East Hampshire District Council

Aquind Interconnector Project
Application for a Development Consent Order

Response to Deadline Seven

East Hampshire District Council : Response for Deadline Seven

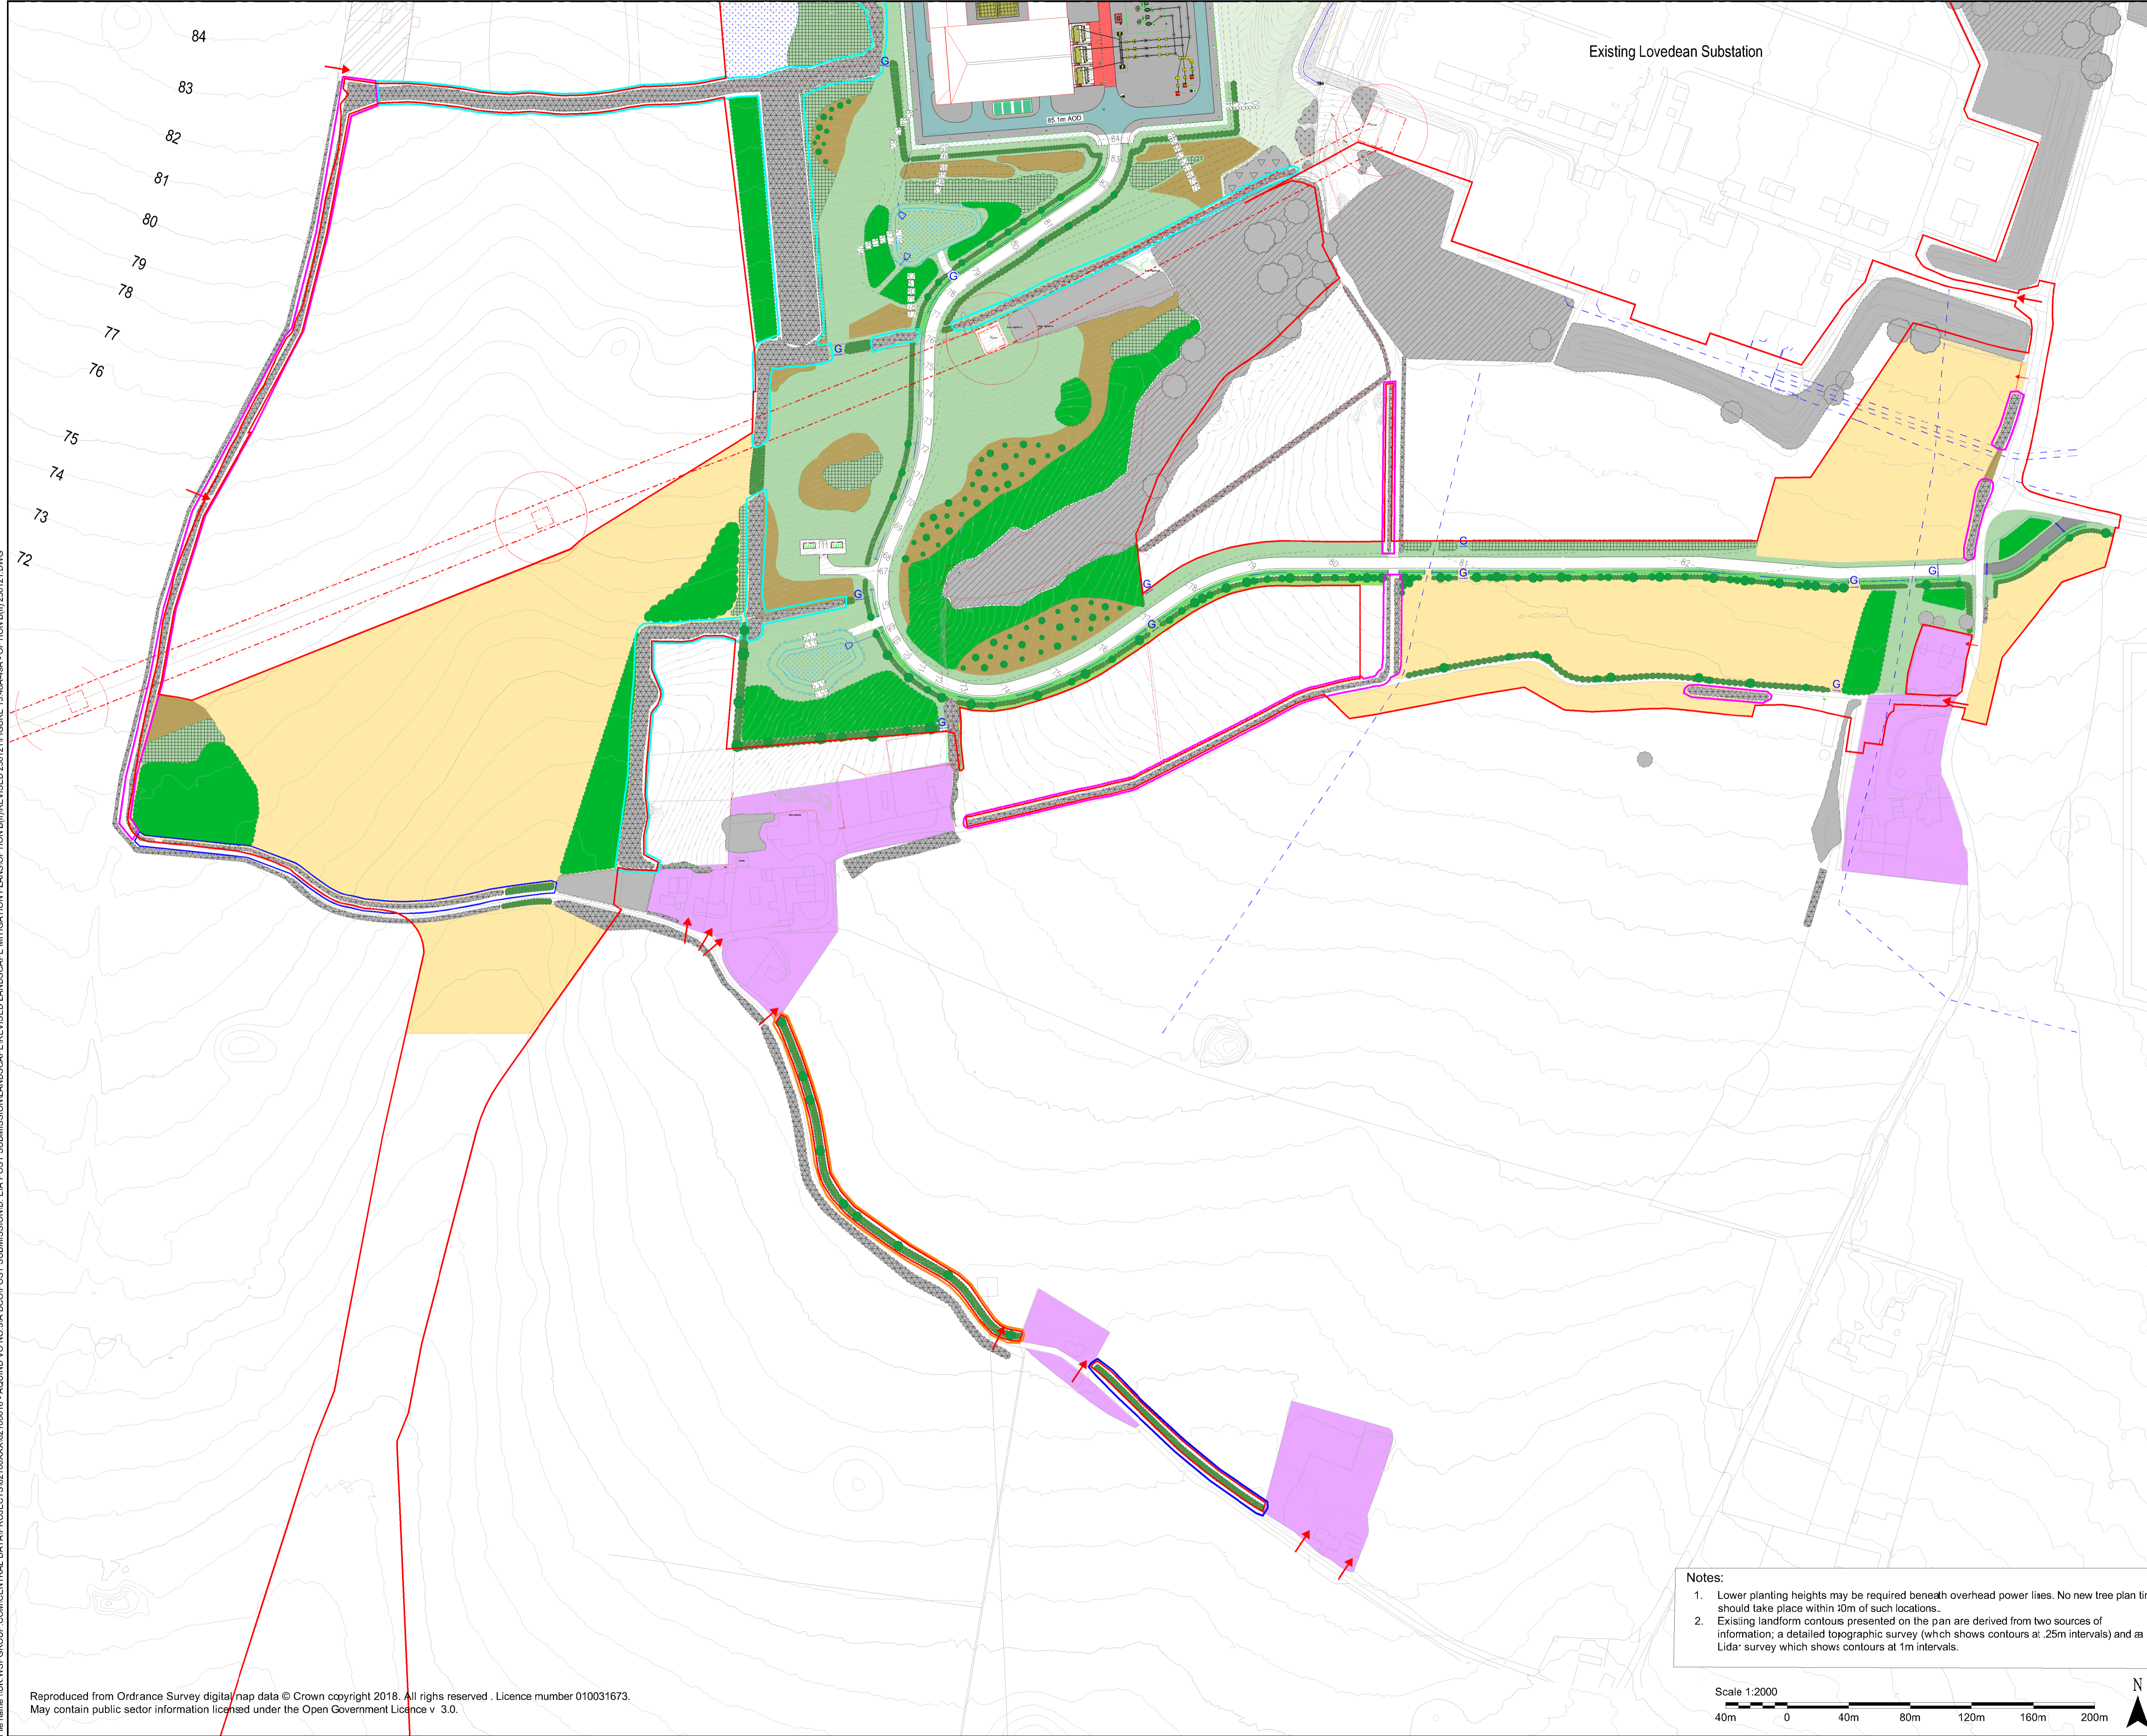
2.2 The amendments to the Landscape and Biodiversity Strategy in light of the ash dieback survey are noted. Part of Stoneacre Copse to the south west of the existing electricity substation is within the EHDC area and provides an important landscape screening effect of the existing substation and the proposed Converter building. This is particularly important in views from the public footpath located to the south of the substation. The ash dieback survey has identified that the disease is prevalent within all woodland areas around the substation and some hedgerows and that all ash trees will likely

be lost within a decade. Stoneacre Copse is ancient woodland and ash forms a large proportion of the mature canopy, particularly at its southern extent.

- 2.3 The effect of loss of ash trees from the area will have a significant short - medium term effect and would increase the visual impact of the development. The Applicant acknowledges the effectiveness of the screening of the woodland would reduce as a result of ash die back though the loss of leaf cover and tree removal and that this impact would continue until new planting becomes established. It is agreed with the change to significance of impacts set out in the ES on the public right of way to the south from Minor to Moderate (not significant) to Moderate (significant). The loss of density to the woodland cover would weaken the screening effect of the woodland and increase visual impact of the Converter Building.

- 2.4 Proposed mitigation planting would take several years to take meaningful effect and increases the burden of management. Given the timetable for development works, any remaining ash trees would likely provide minimal screening benefit and the development Converter building would likely have reduced screening effect for much of its 40 year life. The final planting schedule including species and sizes would be agreed with the relevant LPA and the South Downs National Park Authority.
